AENC-NG-CNS-REP-0326

Norwich to Tilbury

**Document: 8.4.7 Applicant's Comments on any Further Information
or Submissions Received by Deadline 1**

Planning Inspectorate Reference: EN020027

Title:
 Figure 11.6 - Historic Environment -
 Phase 2 Geophysical Survey
 Preliminary Results
 Page 8 of 35

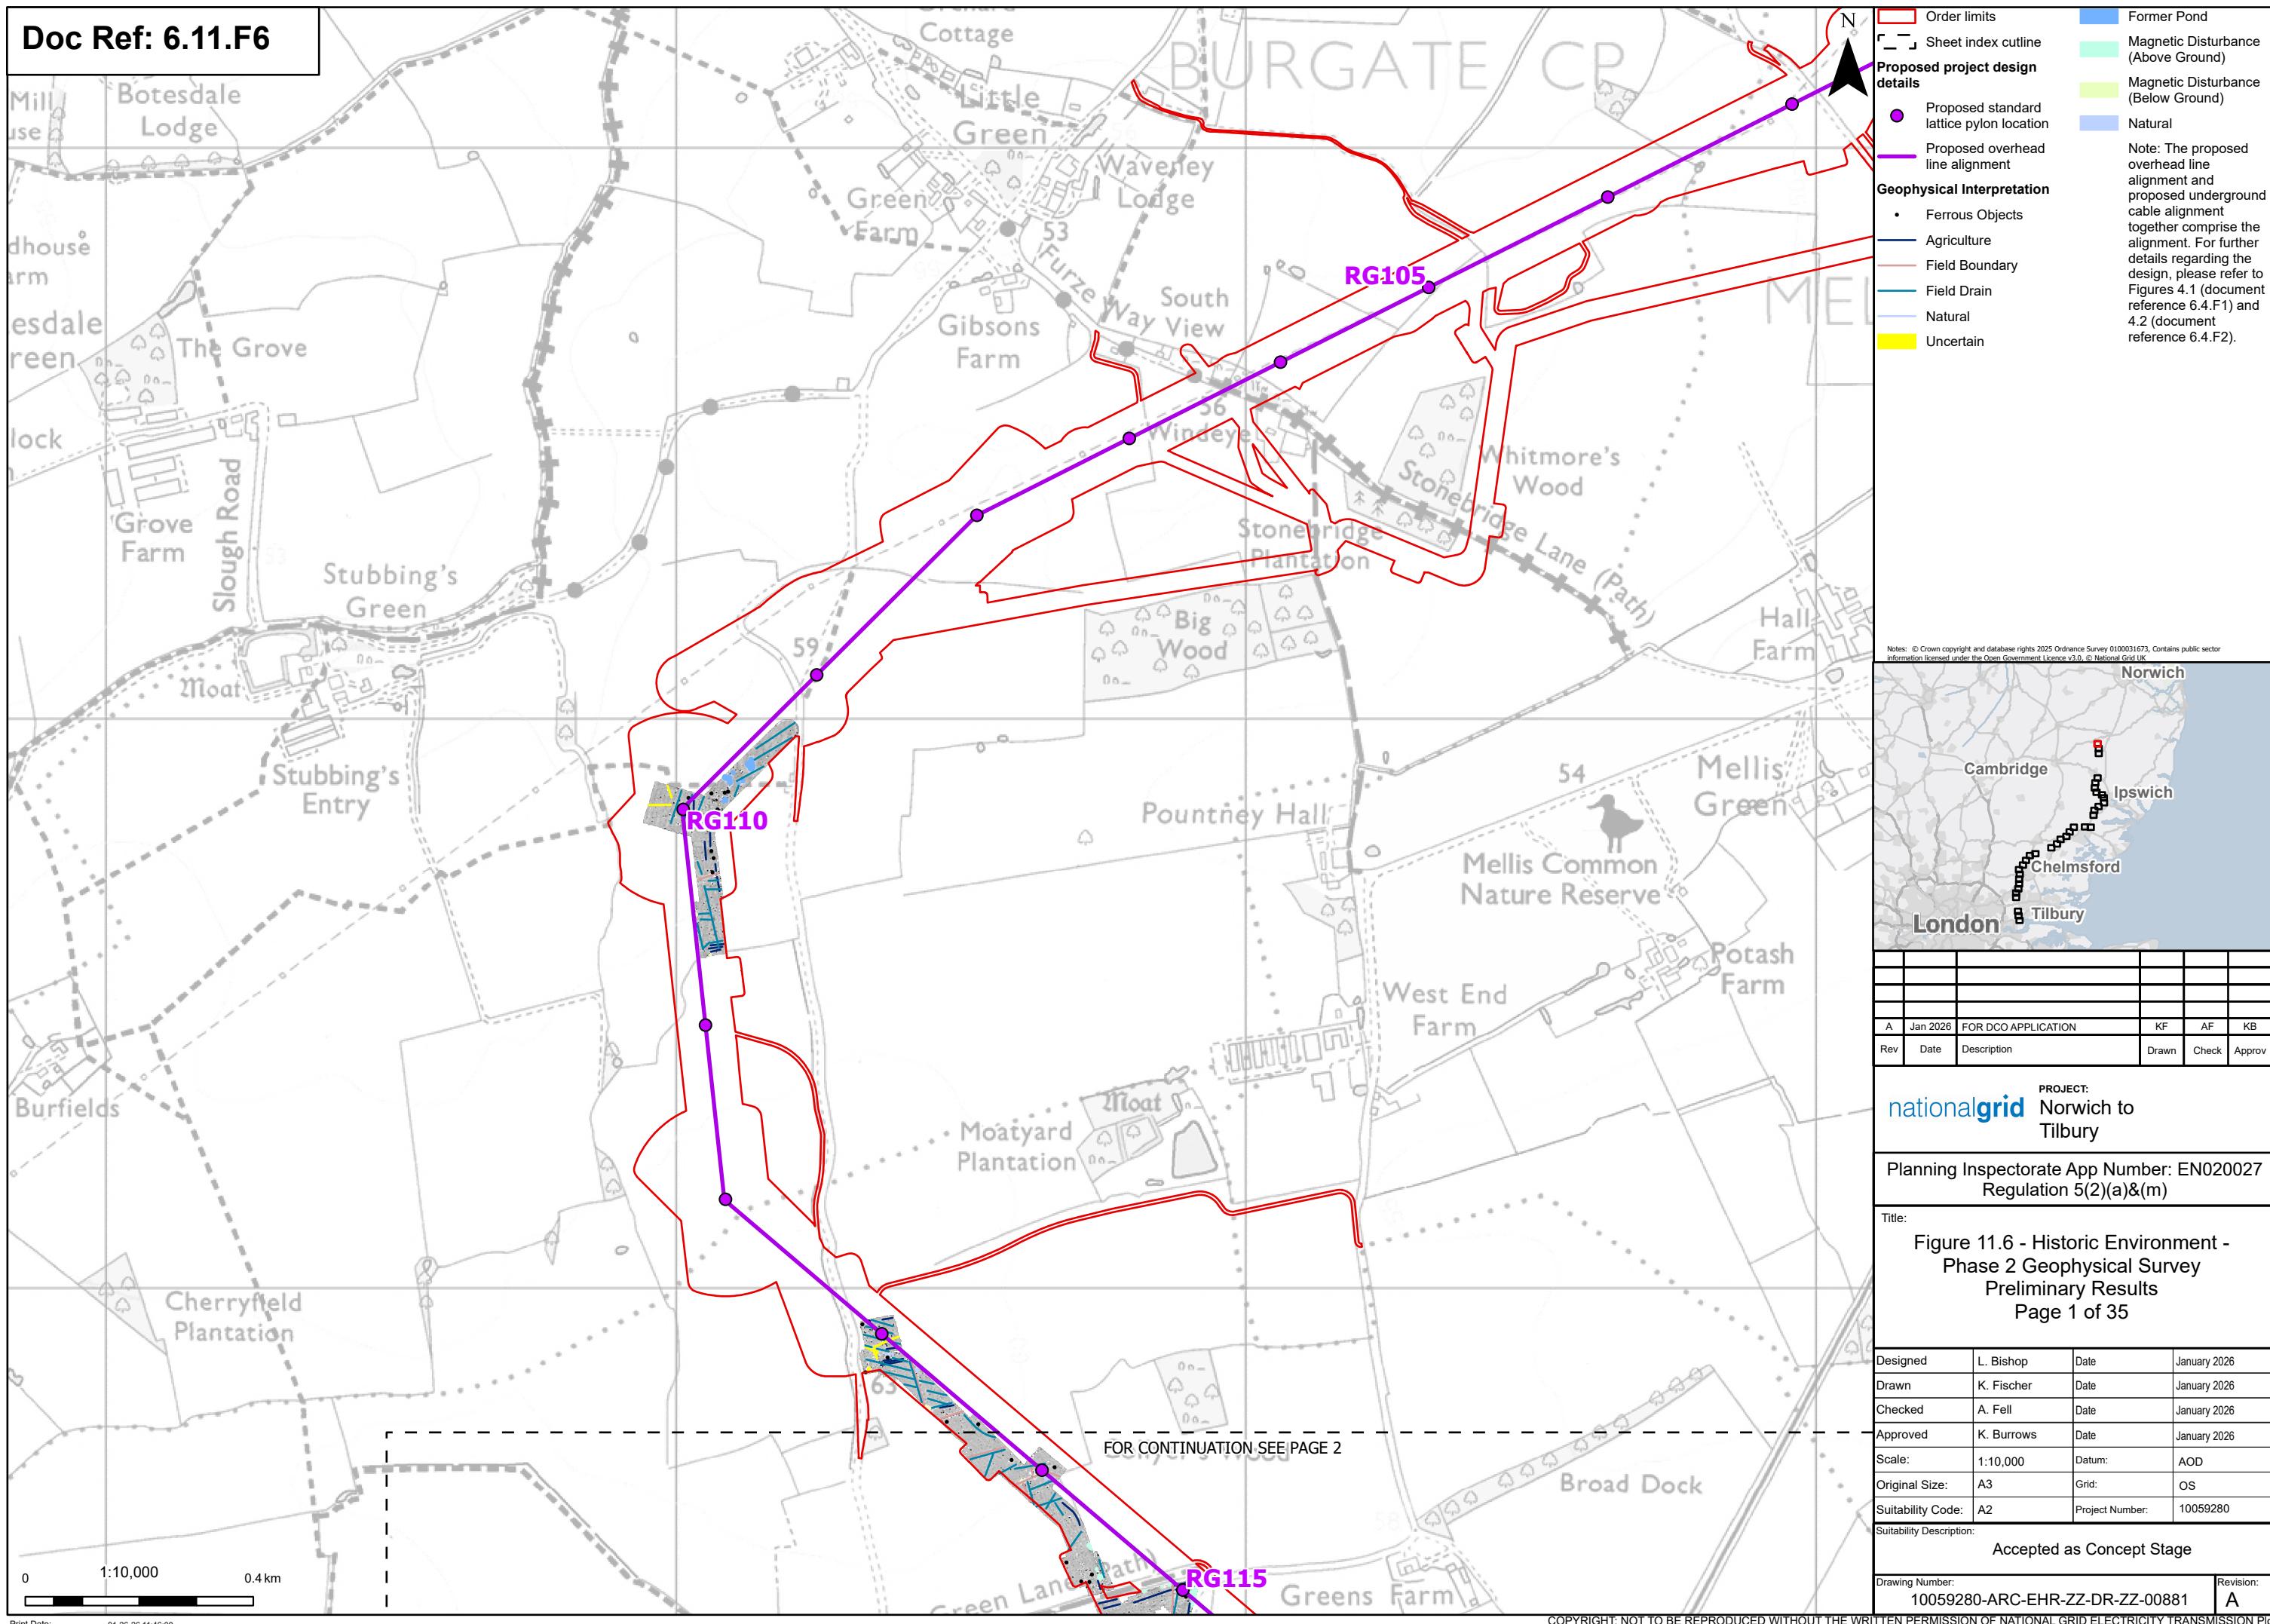
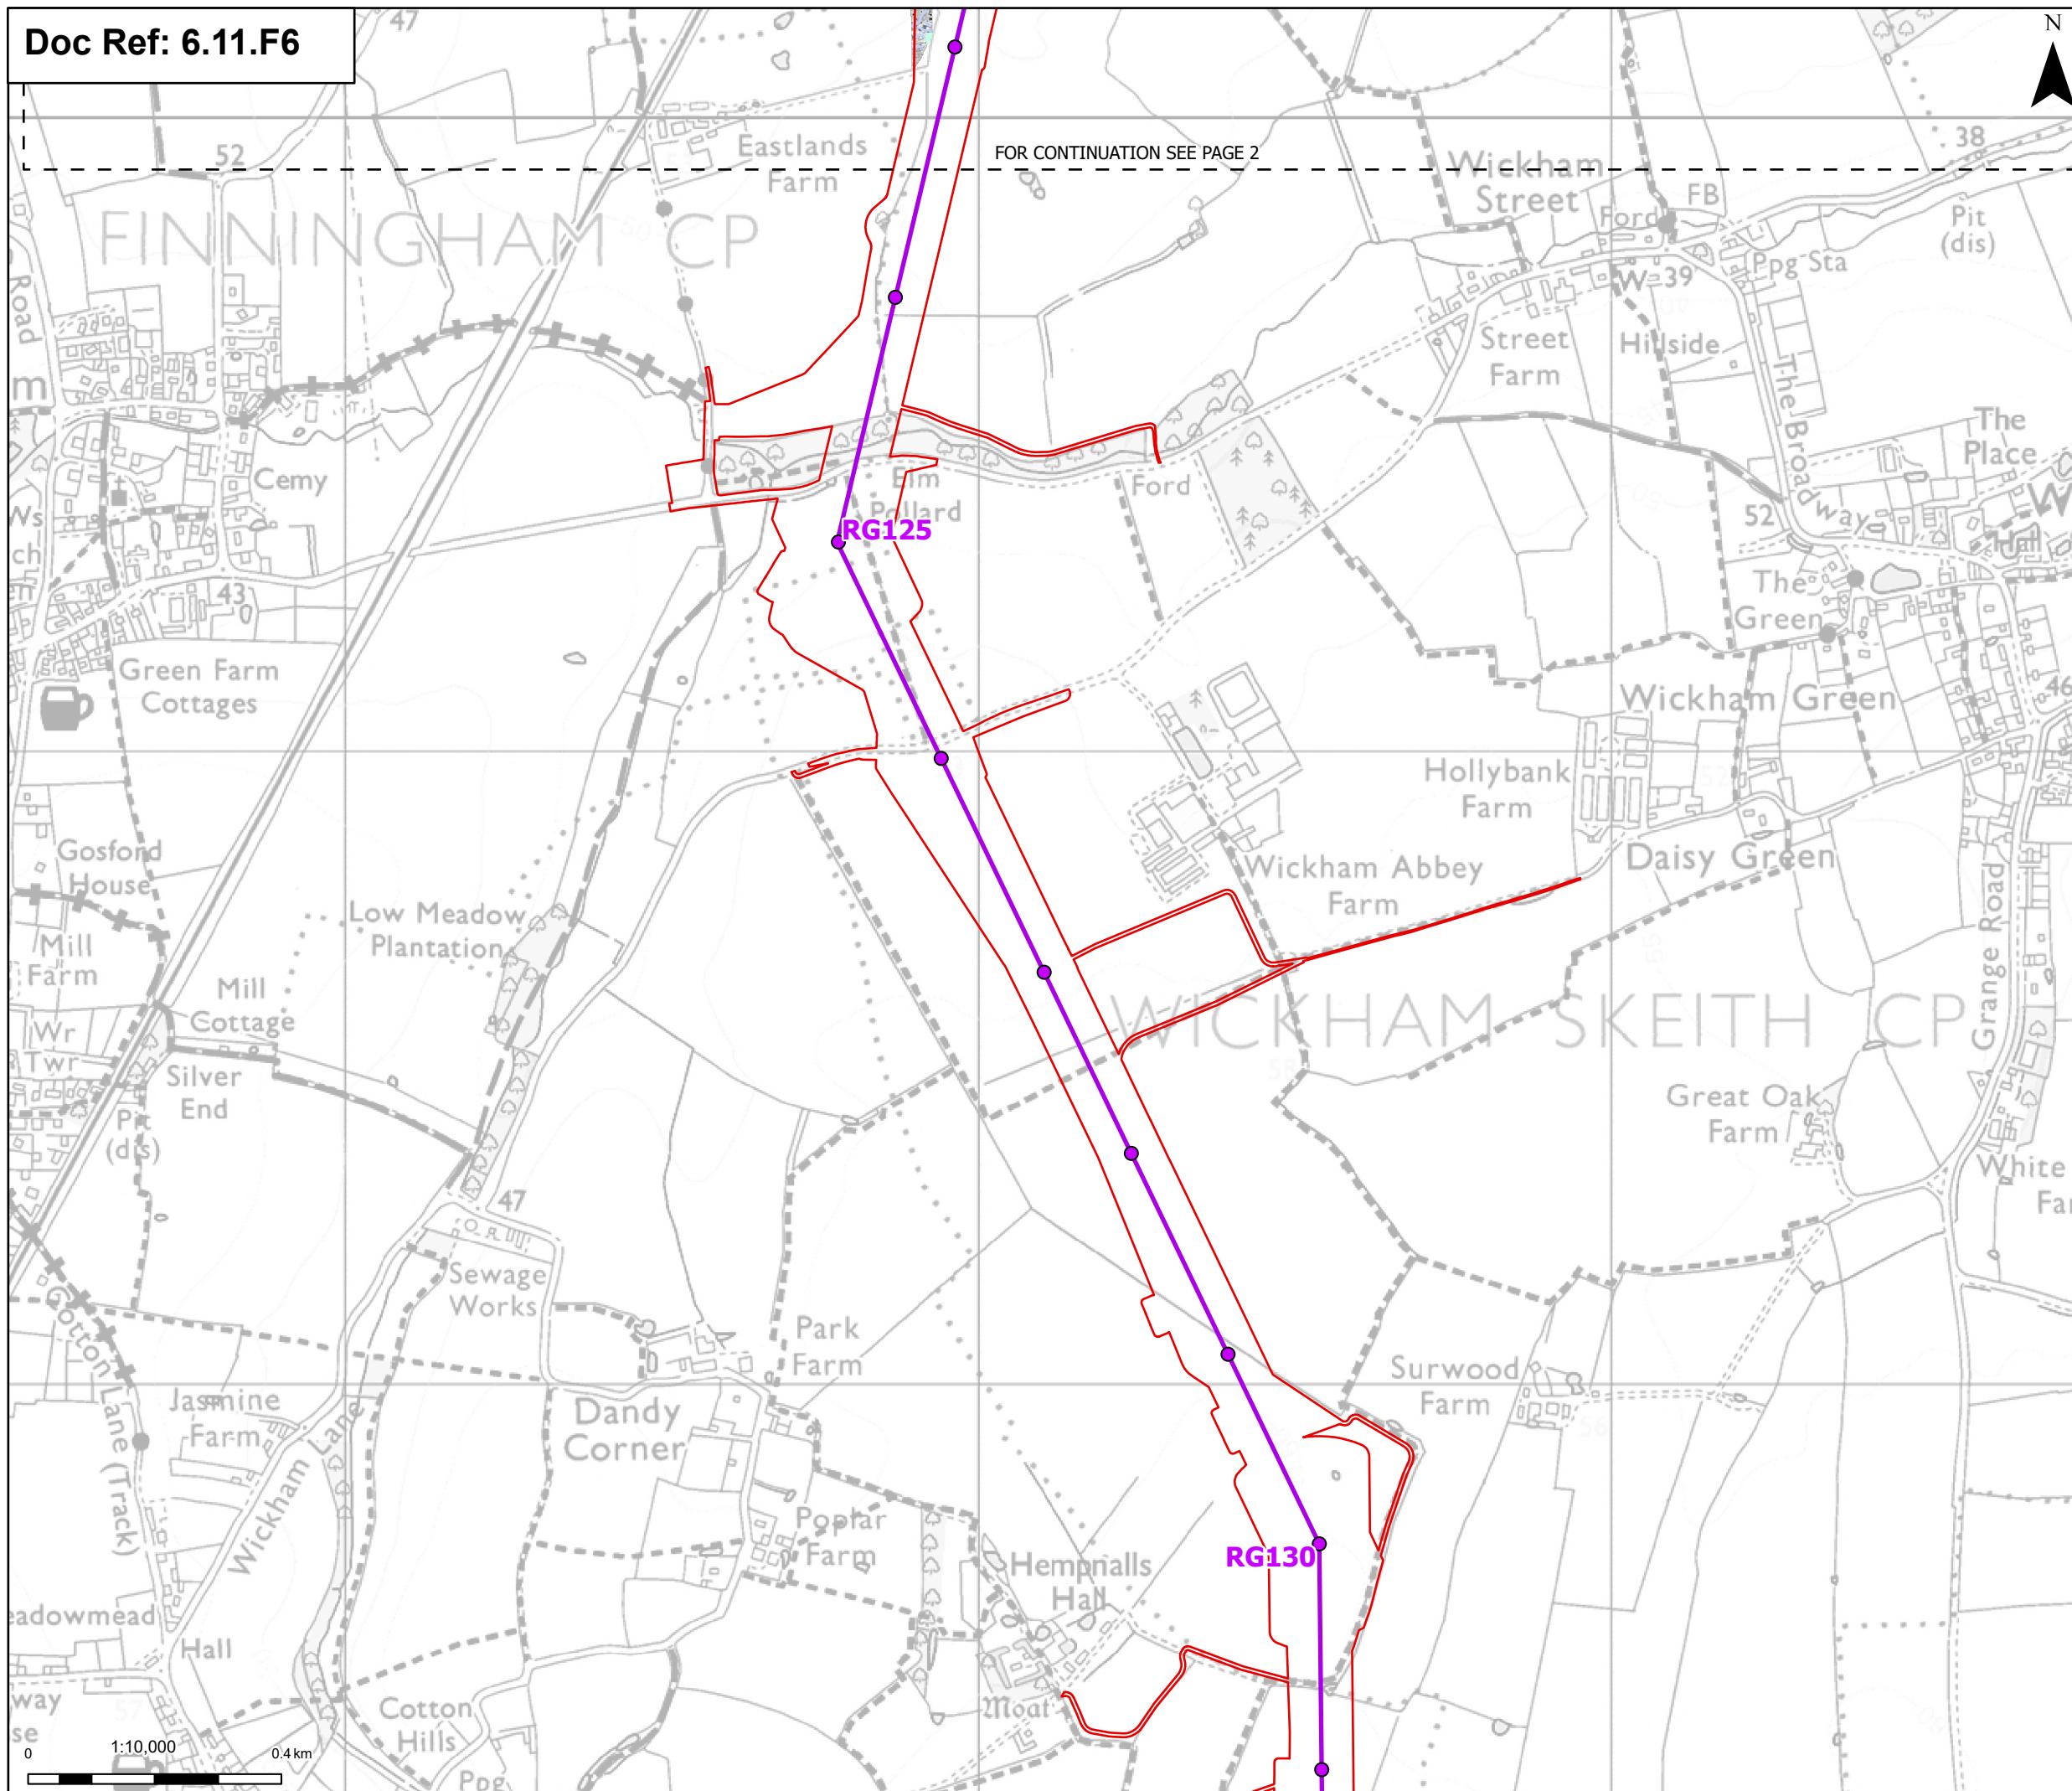
5.27-5.28	<p>5.27 In the Ardleigh PC Historic Environment submission for the 2024 statutory consultation the inadequacy of geophysical survey techniques on the soils in this area was highlighted, as established in NGET's 2024 "EACN Substation Geophysical Survey Report". The issue was highlighted again in the Ardleigh PC response to the 2025 "Essex 2" targeted consultation where NGET documentation showed that geophysical survey results were still being extensively relied upon for locating infrastructure in this archaeologically sensitive area.</p> <p>5.28 Despite this feedback, it is noted that the area of concern was still treated as a "priority geophysical survey" area, as denoted by the green cross hatching around pylons TB5 to TB8 in the following figure, as opposed to a "priority archaeological trial trenching" area. The image was obtained from page 13 of "Figure 11.4 – Historic Environment – Geophysical Survey and Archaeological Trial Trenching Priority</p>	<p>The Applicant notes Ardleigh Parish Council's comments regarding the limitations of geophysical survey techniques in certain soil conditions. A programme of archaeological evaluation including both geophysical surveys and trial trenching, has been discussed and agreed with Local Planning Authority Archaeological Advisors and Historic England, as set out in the relevant Statements of Common Ground (5.9 Draft Statement of Common Ground [APP-089 to APP-100 and APP-102]). All completed interim and assessment reports for geophysical survey and trial trenching were submitted with the application for development consent in 6.11.A4 Environmental Statement Appendix 11.4 - Geophysical Survey Results Report [APP-212] and 6.11.A5 Environmental Statement Appendix 11.5 - Trial Trenching Results Report [APP-213] along with the reports of geoarchaeological and archaeological monitoring of ground investigation works (6.11.A6 Environmental Statement Appendix 11.6 - Geoarchaeological Monitoring of Ground Investigation Works Report [APP-214]).</p> <p>The archaeological evaluation work (geophysics and trial trenching) has continued since the submission of the application for development consent, continuing the Applicant's commitment to the historic environment potentially affected by the Project. The results of the fieldwork up to the end of December 2025 were submitted to the Planning Inspectorate in January 2026 as 6.11 Environmental Statement Chapter 11 - Historic Environment [AS-068] to</p>

Ref	Matter Raised	Applicant's Response
	Areas", submitted by NGET as part of the DCO application	<p data-bbox="1003 180 2121 475">6.11.F6 Environmental Statement Figure 11.6 - Phase 2 Geophysical Survey Preliminary Results [AS-083], of which the historic environment stakeholders are aware. The Phase 2 stage of the geophysical survey and trial trenching will continue throughout 2026, and all the results of this work will be shared with the Local Planning Authority Archaeological Advisors for approval as discussed at monthly meetings and set out in 7.5 Outline Archaeological Mitigation Strategy and Outline Written Scheme of Investigation [APP-328].</p> <p data-bbox="1003 483 2121 783">During the phase 2 archaeological trial trenching, where geophysical techniques are identified as less effective due to local soil conditions, this will be addressed by supplementing the survey with targeted trial trenching, as agreed with archaeological advisors. As illustrated in 6.11.F4 Environmental Statement Figure 11.4 - Phase 1 and 2 Geophysical Survey Areas and Archaeological Trial Trenching Priority Areas (Final Issue B) [AS-082] the Priority archaeological trial trenching survey is completed in the areas adjacent to pylons TB5 and TB6.</p>
